CITY OF ALBUQUERQUE

January 6, 2015

**Re: Kirkpatrick Warehouse
Kirkpatrick Warehouse Drainage Report with Engineer's Stamp dated 11-25-14
Kirkpatrick Grading and Drainage Plan with Engineer's Stamp Dated 12-22-14
(C17D122)**

DC-780 ISOLATOR ROW DETAIL  
NTS

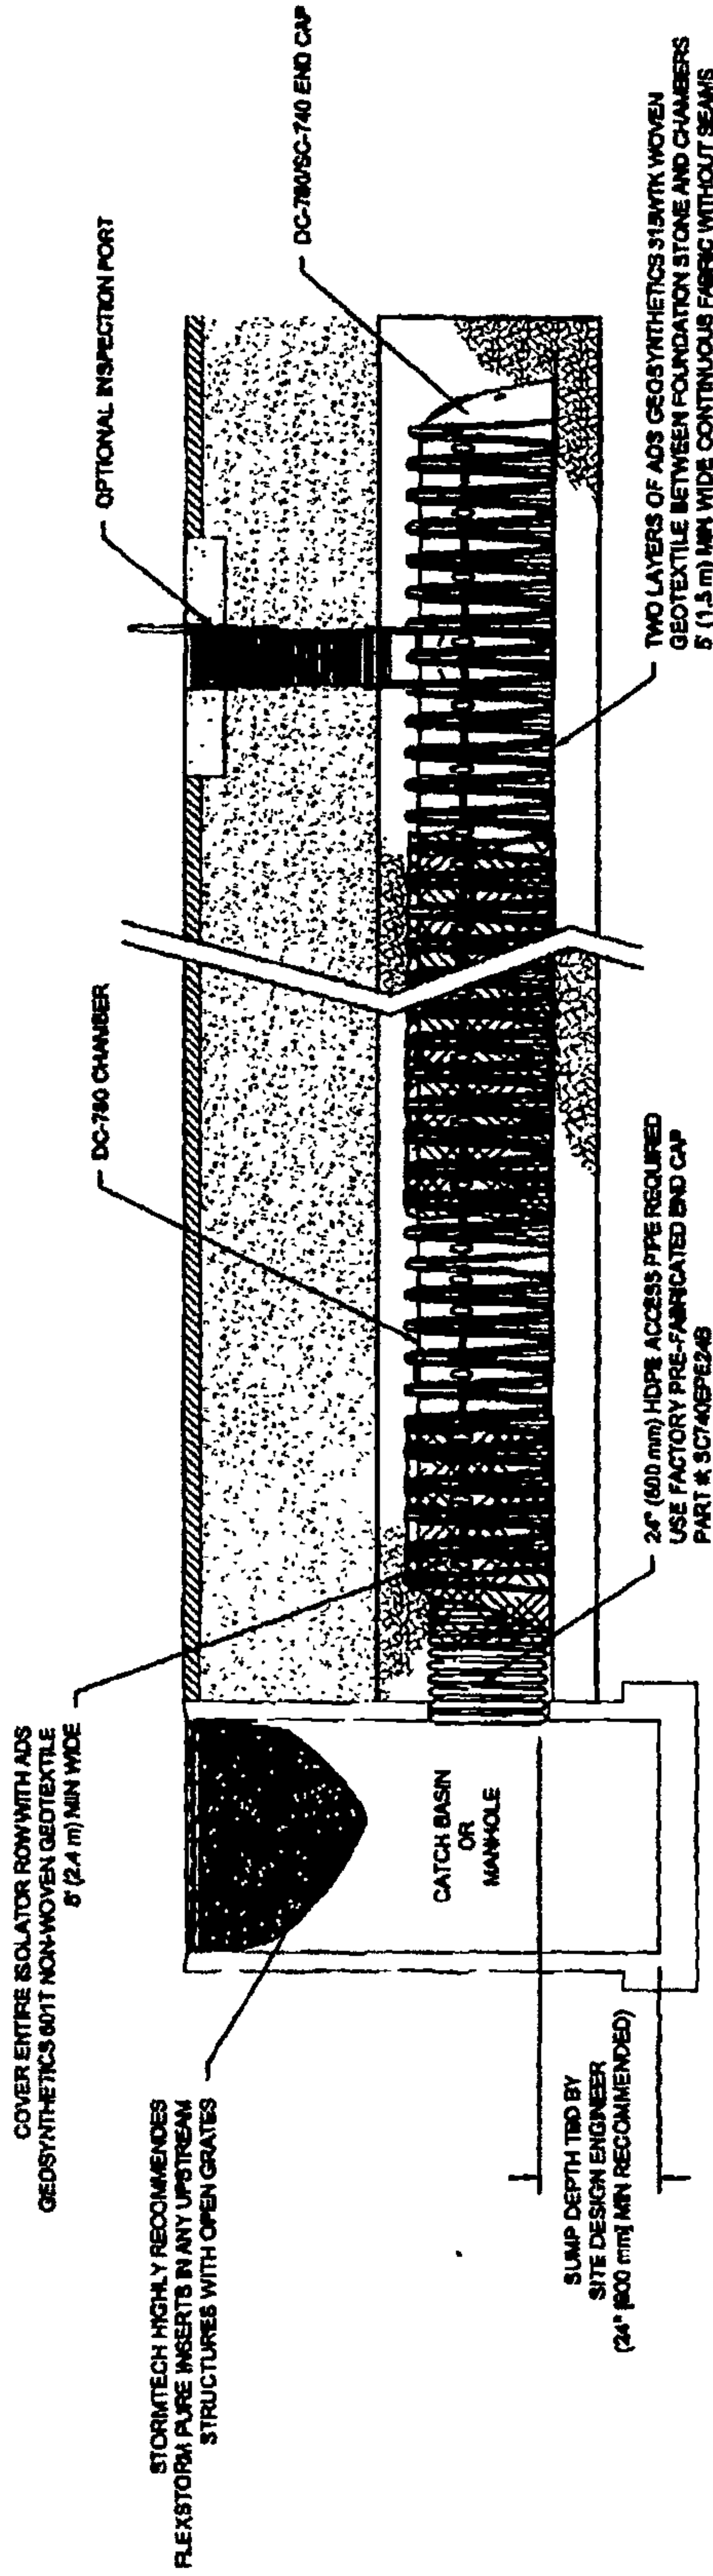
1. Provide a manhole for the drainage going into the Stormtech system. (Remove the Nyloplast inline drain detail.) Provide an invert elevation in the manhole. Also use one row as an isolator row so regular maintenance only has to be done for one row instead of two. Redesign the manifold system so that drainage goes into the isolator row first. Have a slope on the manifold system so sediment does not collect there.
2. When submitting revised plans, please revise the stamp date. Include two set of plans for SO-19 approval.
